**Re: Erection of Rear 2 Storey Extension to Farmhouse and raise height
of detached garage roof to provide storage area.**

At: Unit 1, "Blacker Grange Farm", off Barnsley Road, Blacker Hill, Barnsley.

Application No: 2011 / 0644. Application Date: 26th. May 2011.

CREAM PAINTED TIMBER DOORS

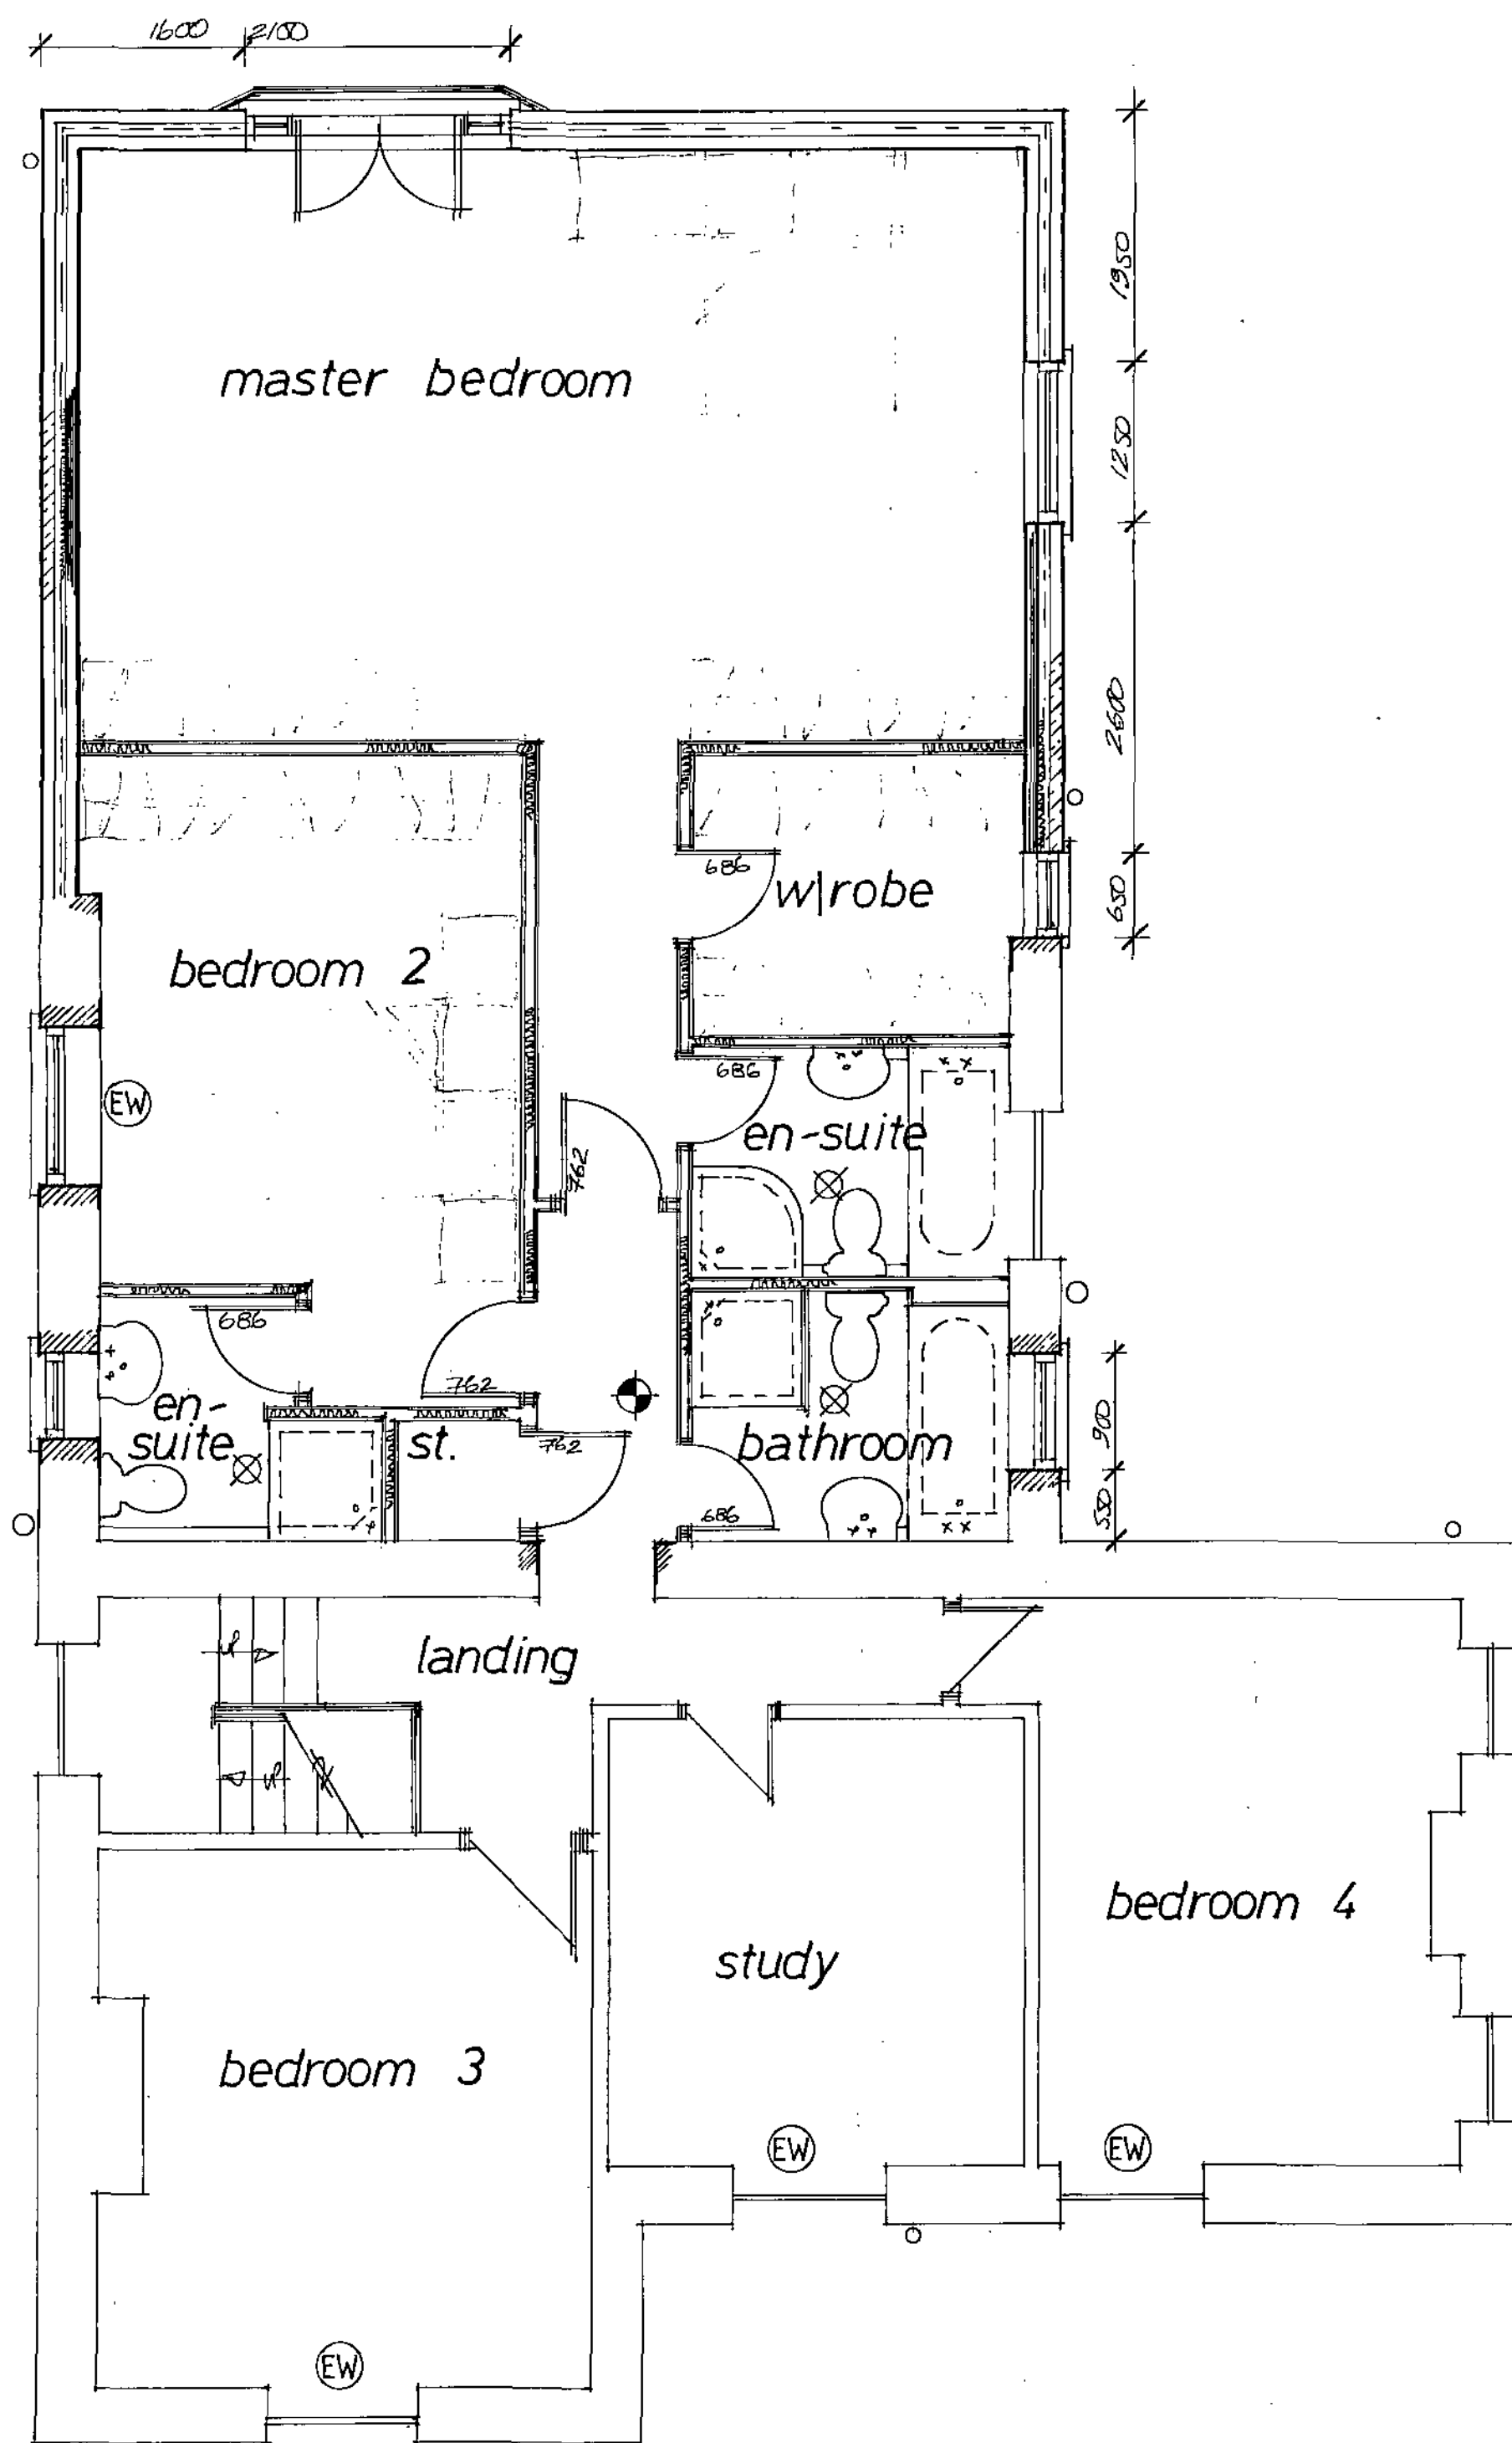
- i) the lowering of the eaves height to this extension construction;
- ii) dropping the window levels;
- iii) introduction of stone dentil detailing to the proposed verges, all as matching the original detailing on the existing property.
